Addendum No. 1

RE: Contract # C204264

Onslow County (W-5602)

NC-172 Sneads Ferry Road From NC-210 To Bridge #17

Match Line -L- Sta. 25 + 50.00, SEE SHEET UO-2

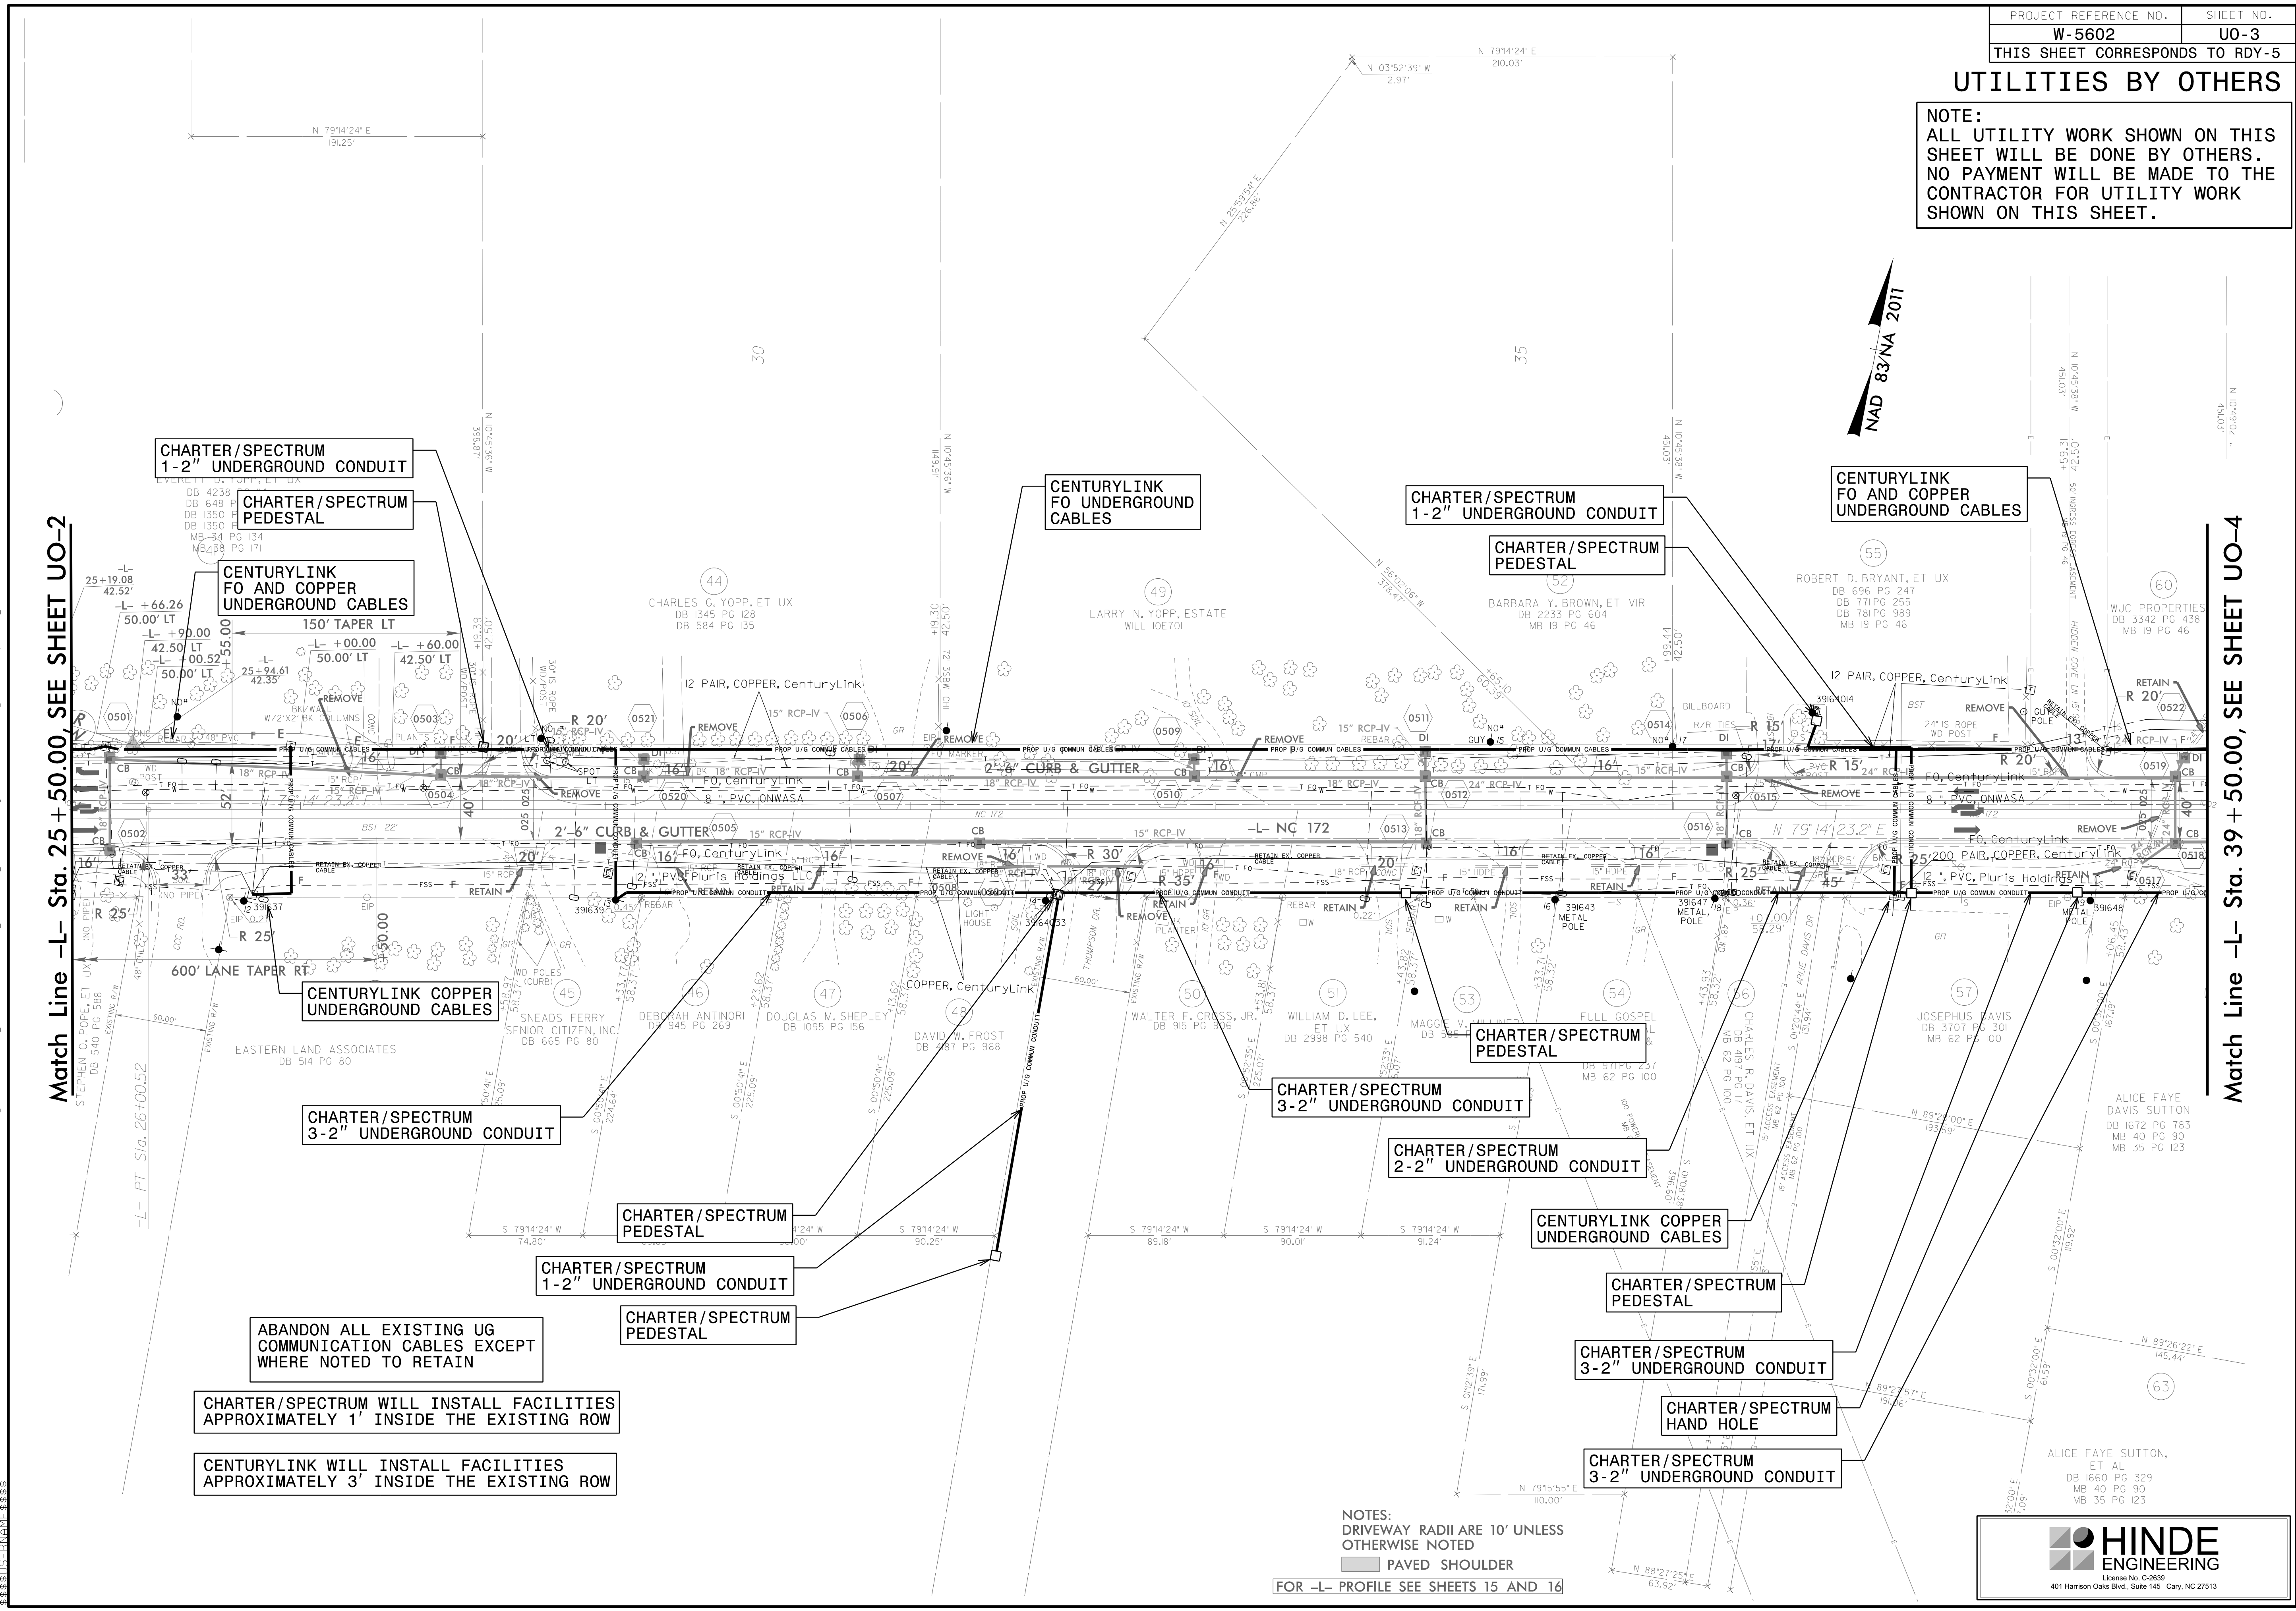
Sheet No.	Revisions
UO-2 thru UO-12	Revised to show additional locations of fiber optic work. This work will be done by others.
